Item No. **Report of the Head of Planning, Transportation and Regeneration**

Address CHERRY LANE CEMETERY SHEPISTON LANE HAYES

Development: A 2.5m extension to the existing 22.5m lattice tower, the removal of six antennas and the installation of twelve antennas, twenty-four Remote Radio Units (RRUs), additional ancillary apparatus and the relocation of three transmission dishes.

LBH Ref Nos: **35298/APP/2021/3325**

DRG No.	Sheet 1 of 2	Rev
1490106-06-153-MD024	24

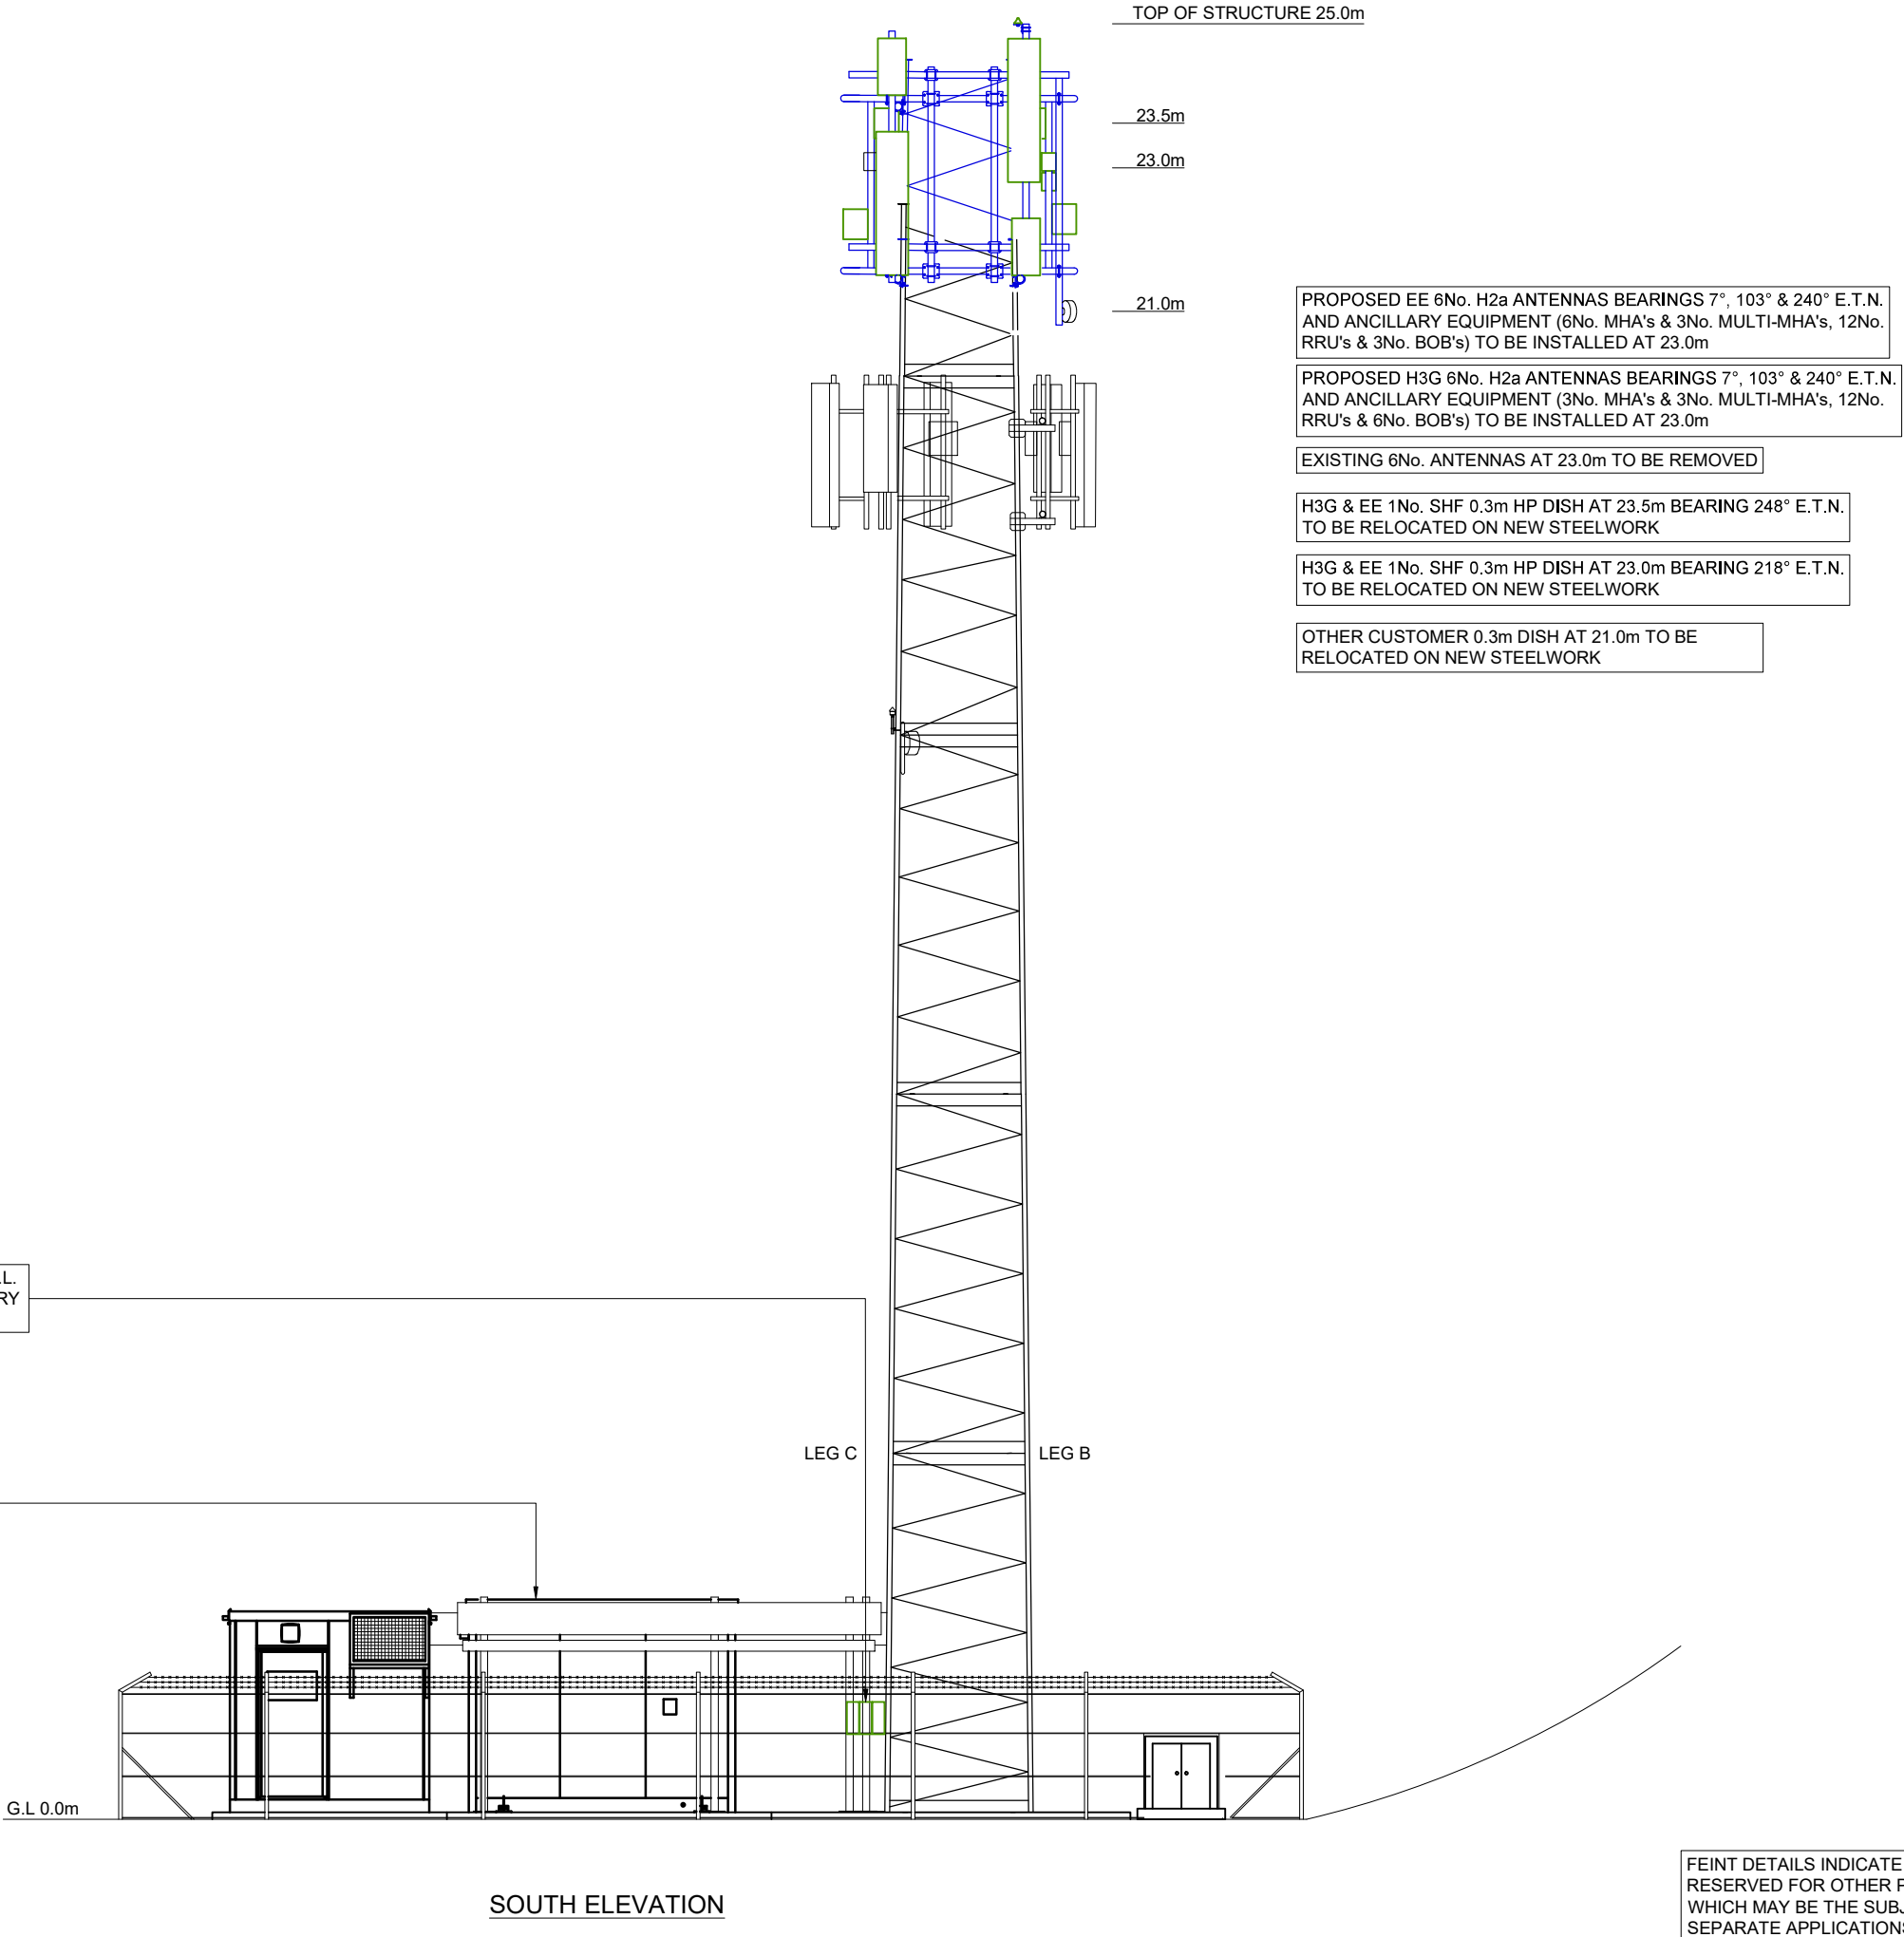
The proposal is an alteration to an existing lattice tower, an extension by 2.5m and the installation of an extra 6 antennas to what is existing (removal of 6, installation of 12 new). The proposal lies to the northern end of the Cherry Lane Cemetery, in an area of a large open expanse of landscaped lawns for quiet contemplation. Given the siting shown on the proposed plans it is noted that the surrounding trees would act as a natural green screen from the ground level telecommunications equipment. However, there would still be a significant portion of the development viewable above the existing tree line. The lattice tower itself would increase in height by over 11 percent. However, it is the combination of the additional antennas (double the existing) and radio units (24) at the top of the tower that would harmfully increase the visual bulk of the development, adversely affecting the open character of the Green Belt and cemetery.

This is considered to be a disproportionate addition to the lattice tower, which in accordance with paragraph 149 of the NPPF, is inappropriate development.

Accordingly the applicant would need to demonstrate that 'very special circumstances' exist and that the harm caused to the Green Belt by this inappropriate development, is clearly outweighed by other considerations. However, this has not been demonstrated. Therefore, due to the significant harm to the character and appearance, in respect to the openness of the Greenbelt, the prior approval of the Local Planning Authority is required and is refused.

Should a revised application be resubmitted it is recommended that the proposal is supported by photo montages or other such imagery that situates the existing and proposed development within its site context.
